Consultation Response from KC Highways Development Management		
2026/90618 7 Crescent Avenue, Ravensthorpe, Dewsbury, WF13 3BD		
Erection of single storey rear and first floor side extensions and formation of vehicular access		
Date Responded: 13/04/26	Responding Officer: M Zenner	Responding Ref: 14-SE/13

PROPOSED SITE PLAN

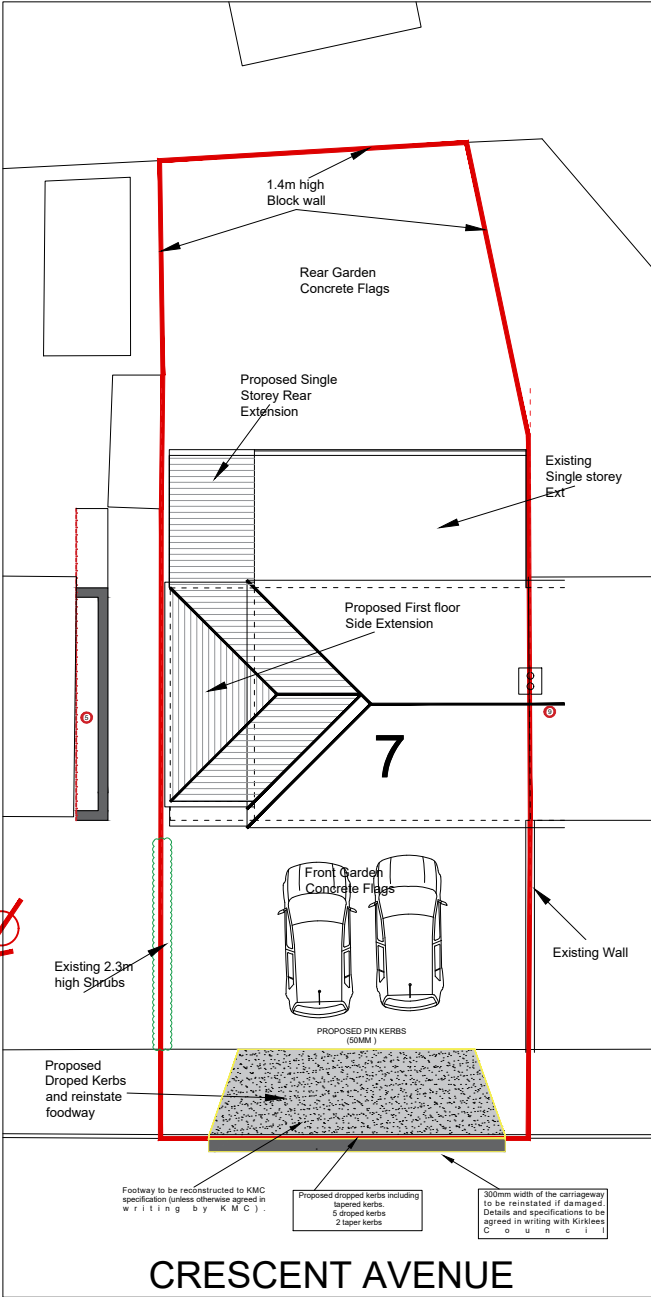
For a double driveway the dimensions required are 5m length x 5.5m width which are provided and it is noted that the pedestrian entrance to the property is offset to the west side of the property and will not be impeded by the proposed driveway.

At present there is no vehicular access along the site boundary. The proposed site plan indicates the provision of a double driveway along the site frontage with the existing shrubs on the east side proposed to be maintained at 2.3m height.

Manual for Streets states that drivers need to be able to see obstructions from 2m high down to a point 600mm above the carriageway. The latter dimension is used to ensure small children can be seen. Ideally pedestrian visibility splays of 2m x 2m should be provided at either side of the proposed driveway.

Therefore, amendments will be required to the boundary treatments to afford visibility of pedestrians approaching the site

The Kirklees Highway Design Guide states that any parking surface located immediately in front of a property should be permeable, bonded/ interlocking and preferably finished with a natural material.

Furthermore, before it can be constructed, the parking area / driveway must have a way of preventing surface water from flowing onto the public highway to comply with Section 163 of the Highways Act 1980.

A plan showing pedestrian intervisibility splays of 2m by 2m at the side of the driveway shall be submitted to and approved in writing by the Local Planning Authority. The pedestrian intervisibility splays shall be implemented in accordance with the approved plan and nothing shall be subsequently erected or allowed to grow to a height in excess of 0.6m within the splays.
